MP10\_0057  
RDC 10M684 Vol 2 SYD10/00684  
Dianne Rees  
8849 2237

**SYDNEY  
REGIONAL  
DEVELOPMENT  
ADVISORY  
COMMITTEE**

**CONSTRUCTION OF 298 RESIDENTIAL UNITS WITH BASEMENT CAR PARKING  
AT 132-138 KILLEATON STREET, ST IVES**

SP 1

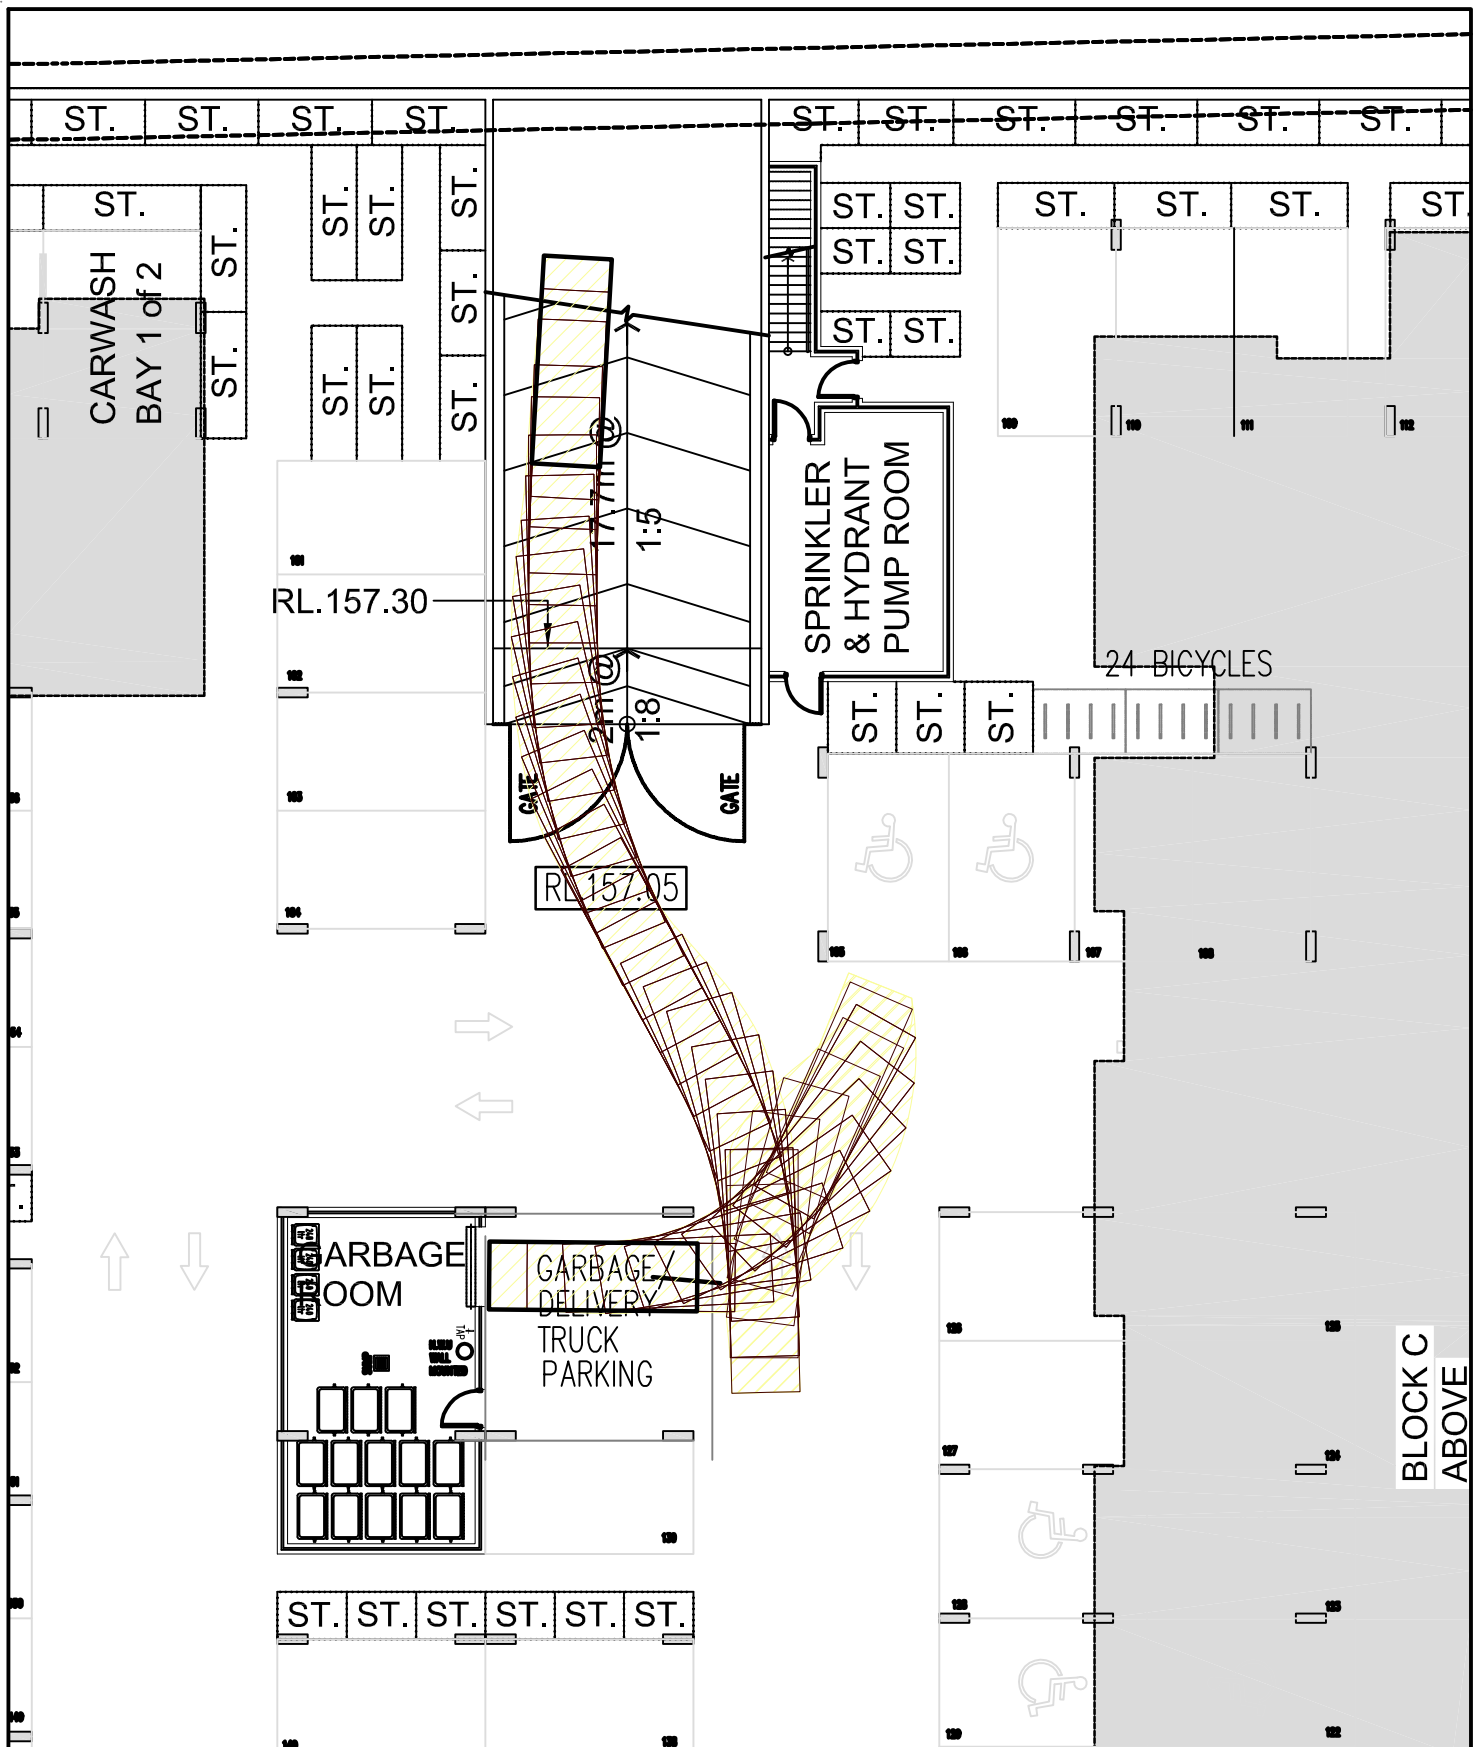
3. Provision for building maintenance vehicles and removalists needs to be provided on-site.
4. The swept path of the longest vehicle (including garbage trucks) entering and exiting the subject site, as well as manoeuvrability through the site, shall be in accordance with AUSTRROADS. In this regard, a plan shall be submitted to the Department for approval, which shows that the proposed development complies with this requirement. The Department should ensure that waste collection vehicles do not park and obstruct circulation aisles within the car park.

5. The proposed waste vehicle turning areas are to be kept clear of any obstacles, including parked cars, at all times.
6. The proposed development will generate additional pedestrian movements in the area. Consideration should be given to ensuring pedestrian safety.
7. Any proposed landscaping and/or fencing must not restrict sight distance to pedestrians and cyclists travelling along the footpath of Killeaton Road
8. All works/regulatory signposting associated with the proposed development are to be at no cost to the RTA.
